FIVE ESTUARIES OFFSHORE WIND FARM

10.34 APPLICANT'S COMMENTS ON DEADLINE 4 SUBMISSIONS

Application Reference:	EN010115
Document Number:	10.34
Revision:	A
Pursuant to:	Deadline 5
Eco-Doc Number:	005558043-01
Date:	January 2025

DRAWING NUMBER: 005023882-01
 APFP Regulation: 5(2)(a)
 Sheet No: 17 of 20

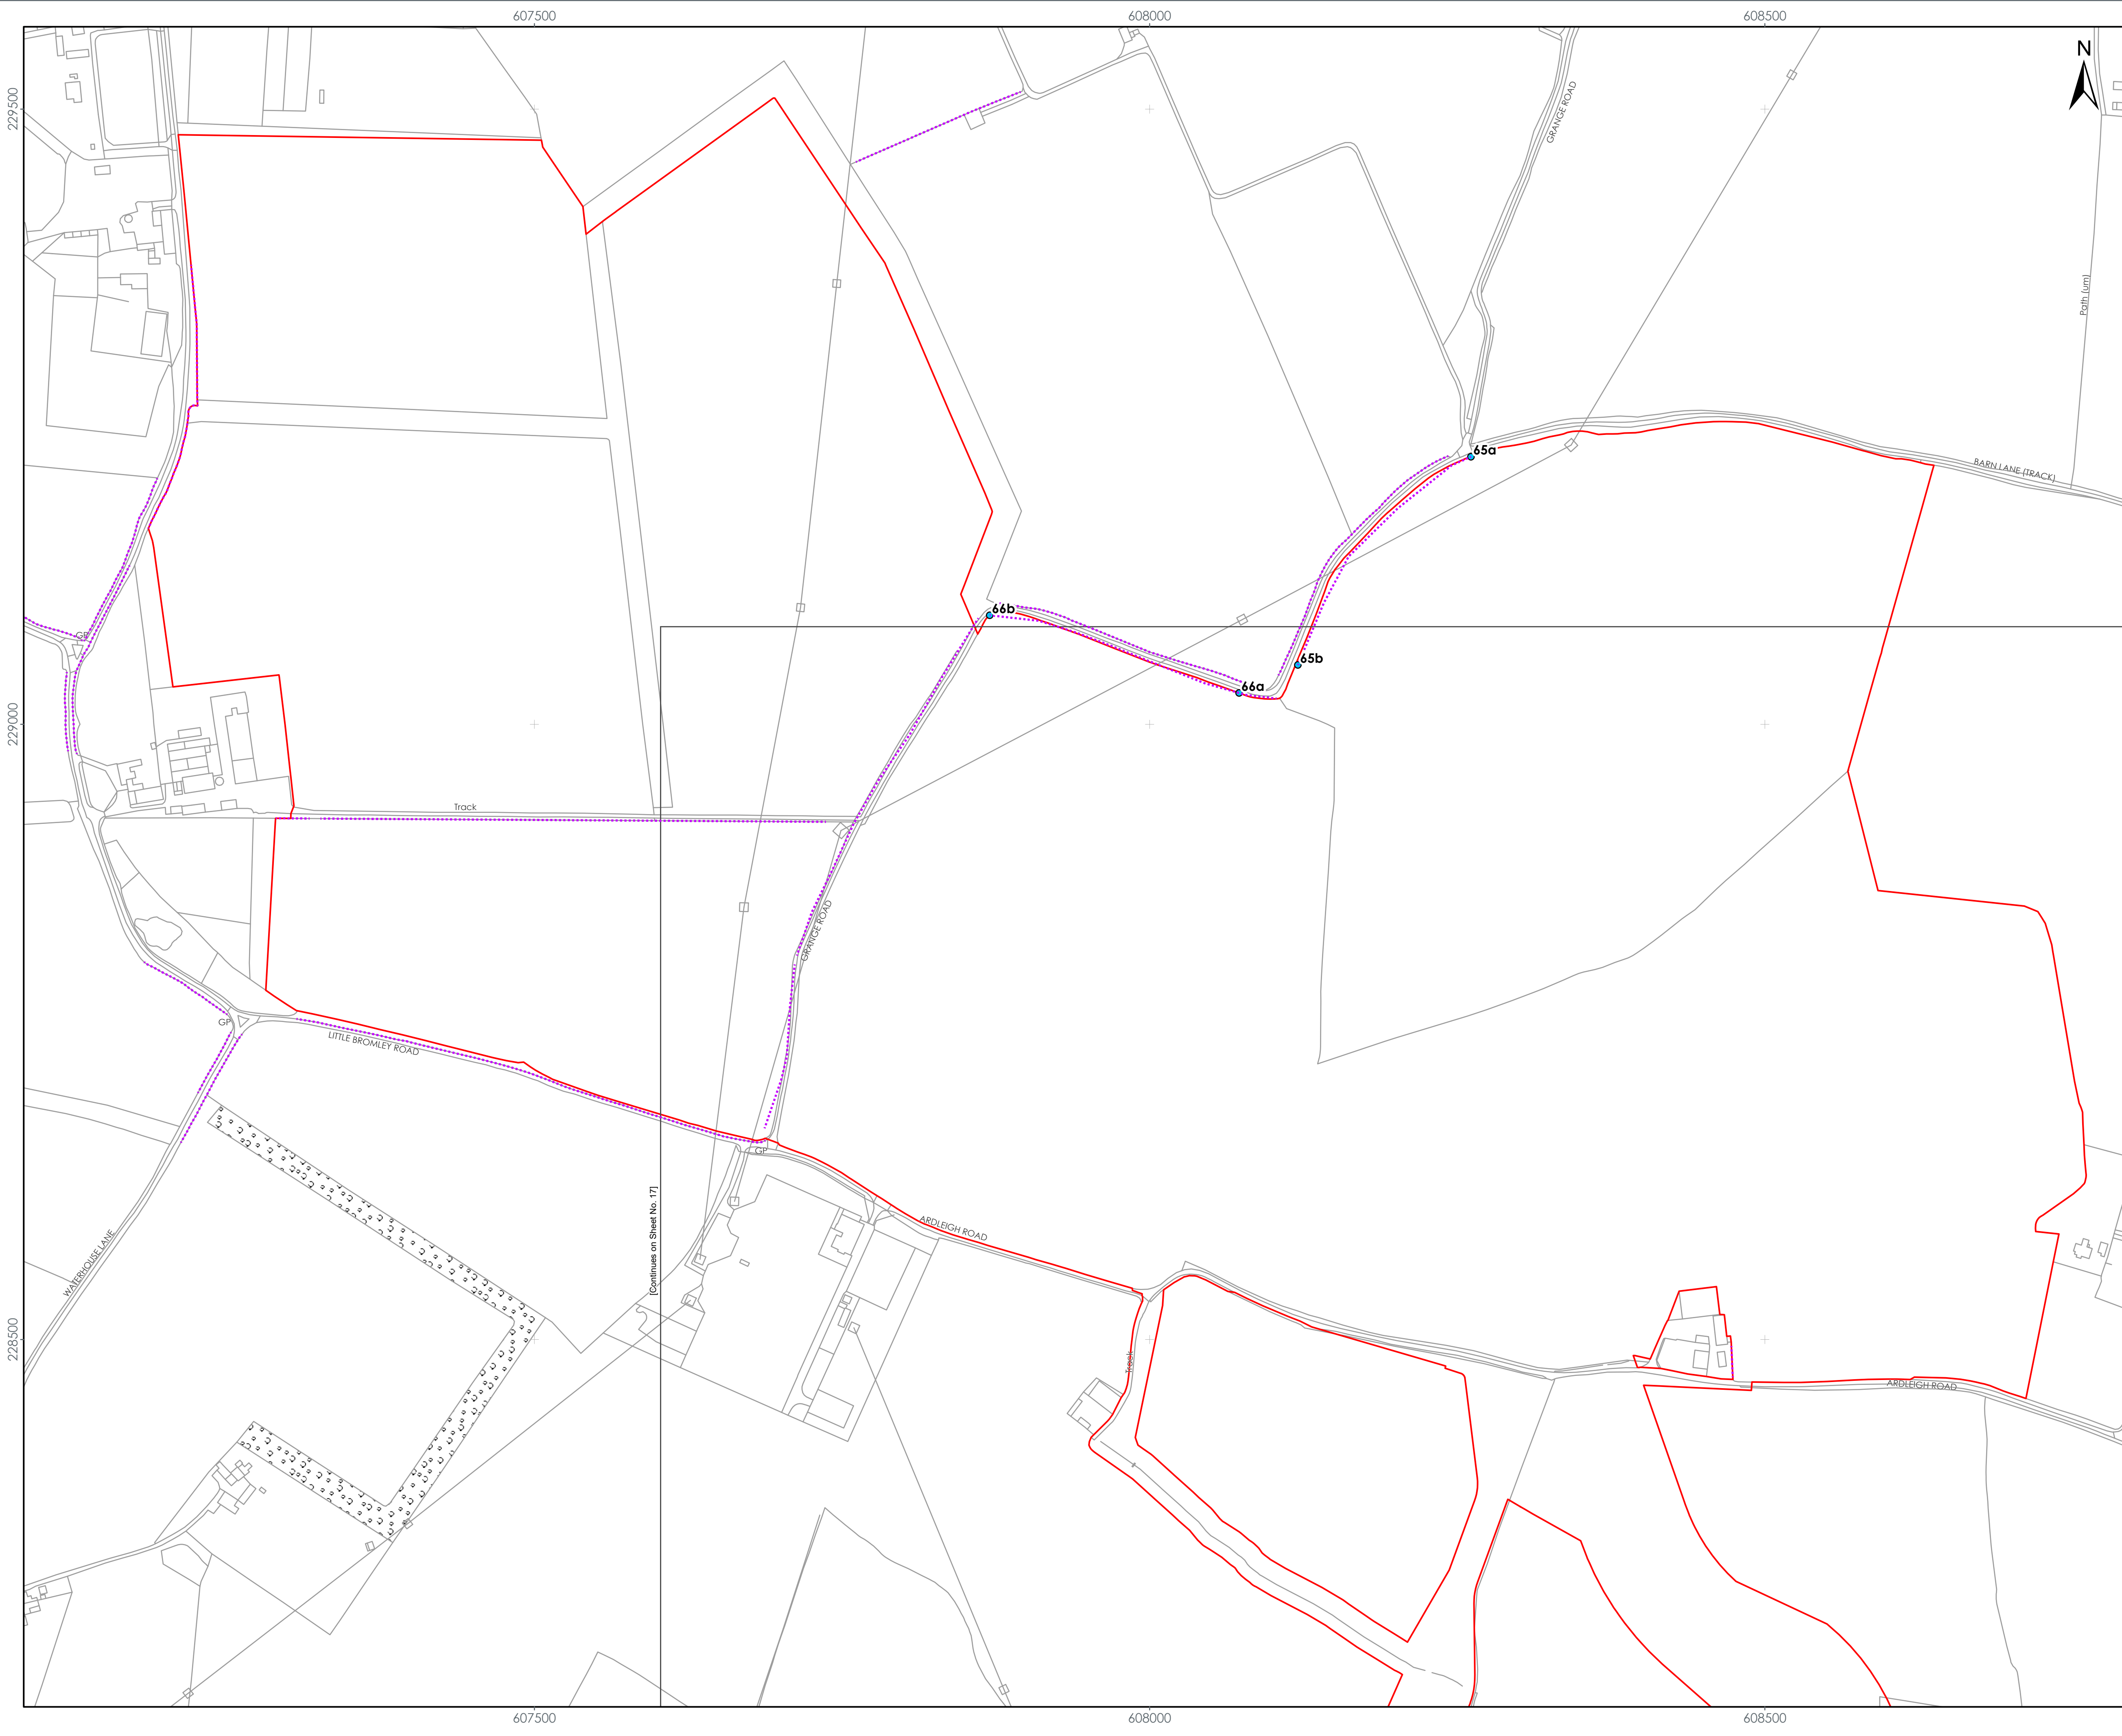
ECC.08	TDC are satisfied that the arboriculture impact assessment is an accurate reflection of the age, quality and condition of the trees. TDC expects to see the root protection area applied to all TPOs that may be affected by the proposals. The root protection area needs to be applied to the following trees; - Sheet 28: 23/00005/TPO trees in G1 oak and tree T1 also oak (see attached Sheet 28 23_00005TPO 1- 500.pdf at Appendix 2)	<p>The powers requested by the Applicant allow for works to be undertaken in the Root Protection Areas (RPA) of the TPO trees as is necessary or lop overhanging branches. As set out in the Outline Landscape and Ecology Management Plan – Revision C [REP2-022], paragraph 5.13 sets out the mitigation that would be implemented if this is necessary.</p> <p>Paragraph 5.13: “Following more detailed design development, pre-commencement/ pre-construction full survey will be undertaken by an appropriately experienced arboriculturist, and the guidance set out in BS5837:2012 Trees in Relation to Construction will be adhered to where applicable. For trees which cannot be avoided, the survey will define specific mitigation</p>

Ref	Summary of Deadline 4 submission OR Excerpt of Deadline 4 submission	Applicant's comments
	- Sheet 37: 91/0021/TPO tree T2 a silver maple (see attached Sheet 37 91_00021TPO 1- 500.pdf at Appendix 2)	<p><i>measures required for trees situated in or immediately adjacent to the working width, including where practical, measures such as the erection of protective fencing in order to minimise the impacts on trees and their roots. These will be specified in the final LEMP, once final scheme design is known."</i></p> <p>The Applicant will include specific reference to TPO trees within this section if the OLEMP is revised at a future deadline.</p>
ECC.09	Vibration impacts from HGV construction traffic, TDC: We acknowledge that it is not included in the scoping report. We would like to see the speed limit along Bentley Road to be restricted to a maximum of 40mph to greatly reduce the impact of vibration on the adjacent properties.	The Applicant has committed to imposing a speed limit along Bentley Road of 40 mph. This is shown on 2.18 Temporary Speed Reduction Plan – Revision B [AS-030] and in schedule 4, part4 of the draft DCO -Revision E [REP4-004]. It is also set out in paragraph 4.1.4 of the Outline Construction Traffic Management Plan – Revision C [AS-055].
